## **Submission Objecting to State Significant Development (SSD-79261463)**

**1-3 Reid Street & 2-4 Woodside Avenue, Lindfield NSW 2070**

TYPICAL LEVEL 2 - 3 PLAN

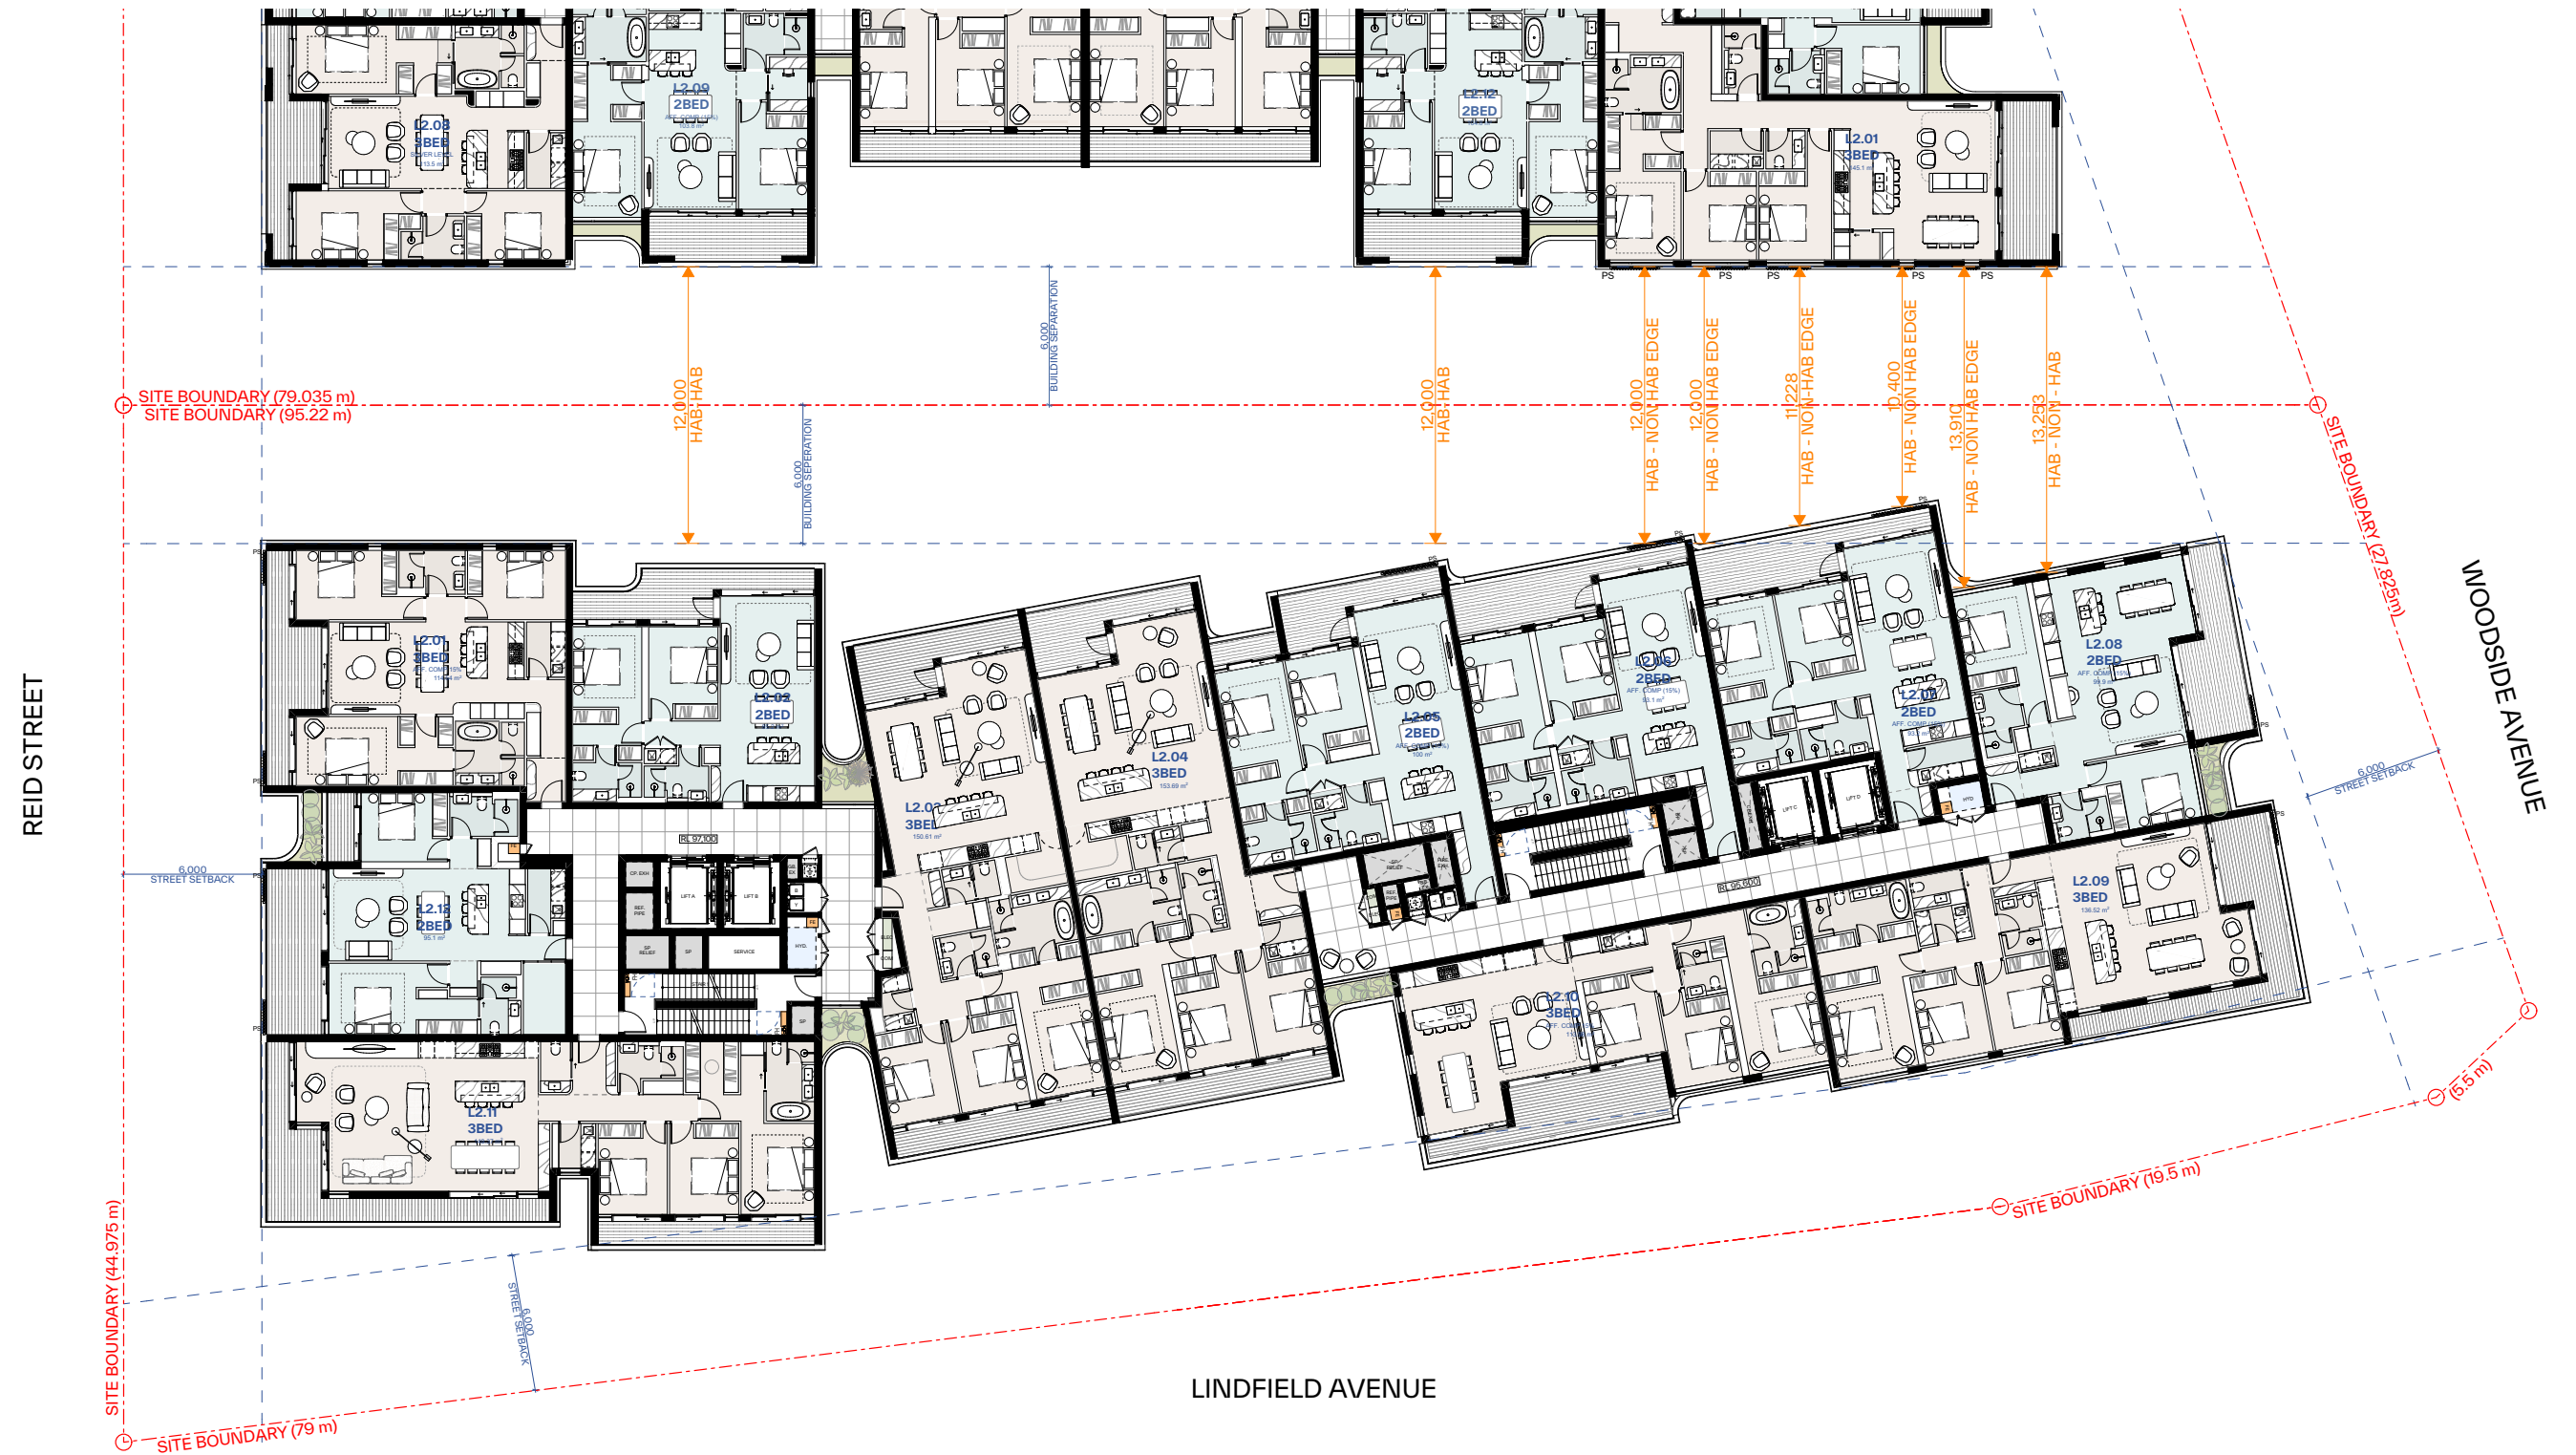
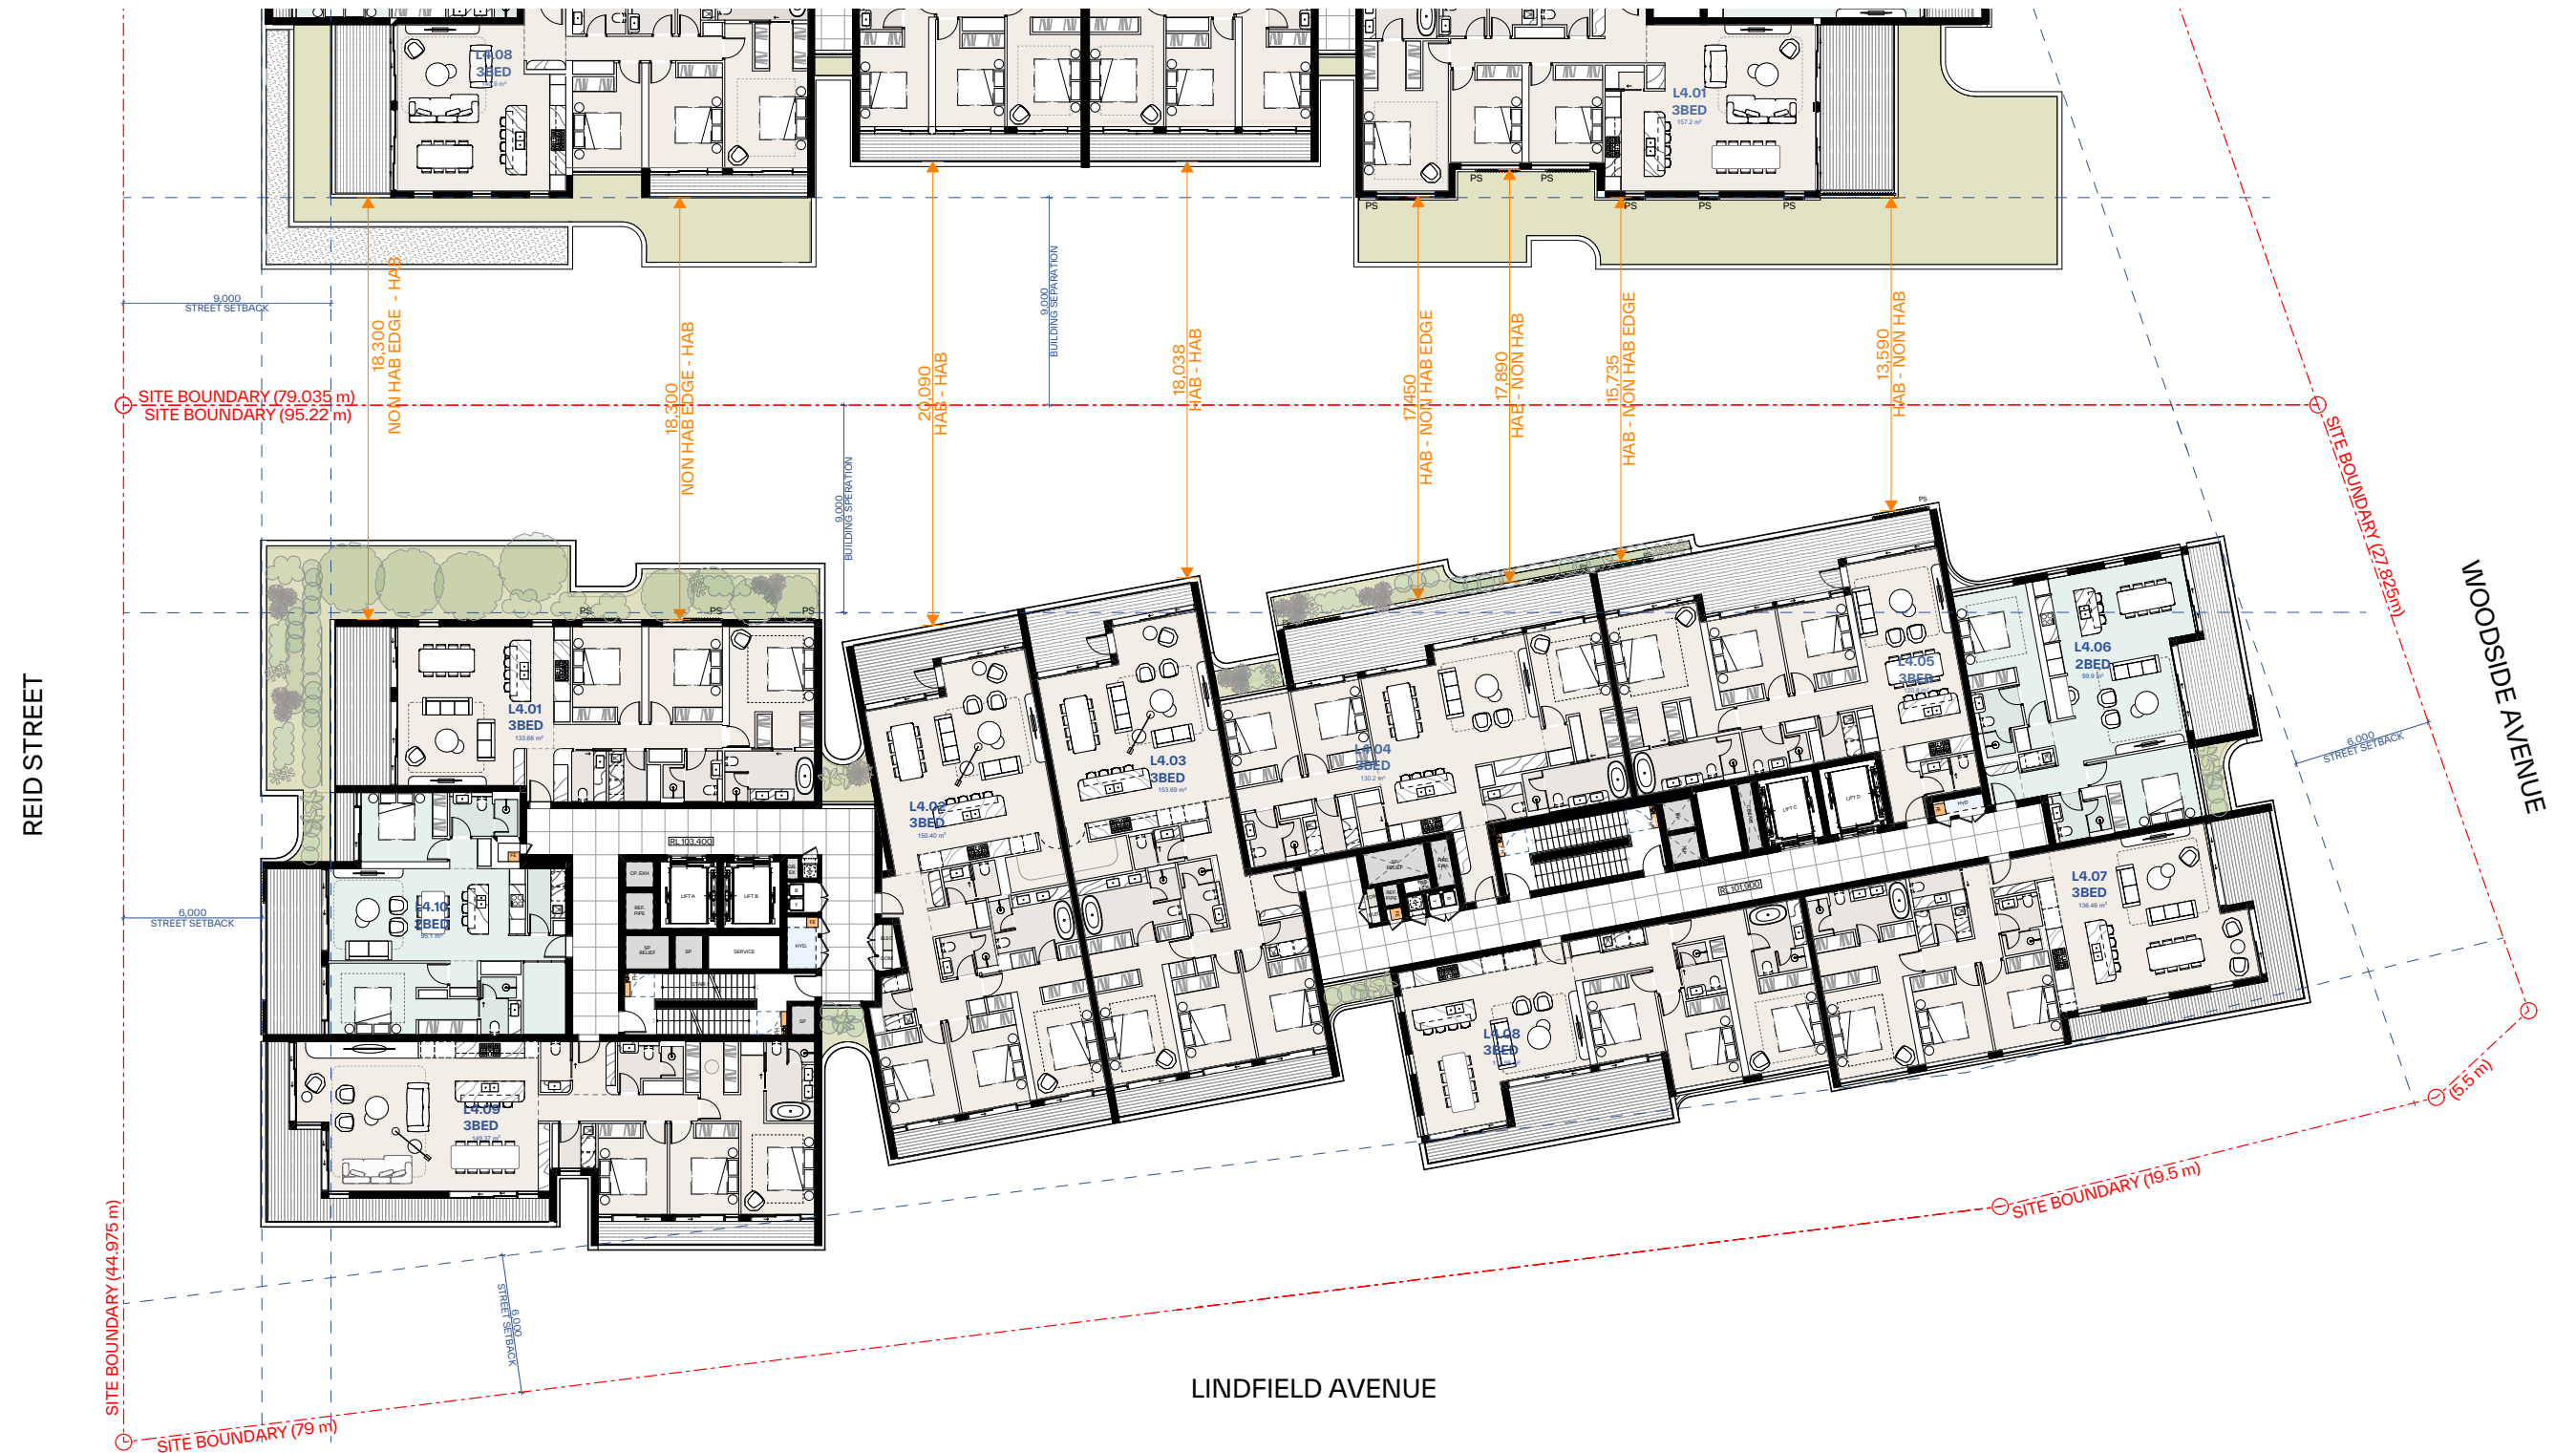
- Upper-level setbacks (Levels 4–6, 7-8) do not universally achieve the required setbacks, again with encroachments (Figure 41 and 42 of EIS), exacerbating overshadowing and bulk impacts.
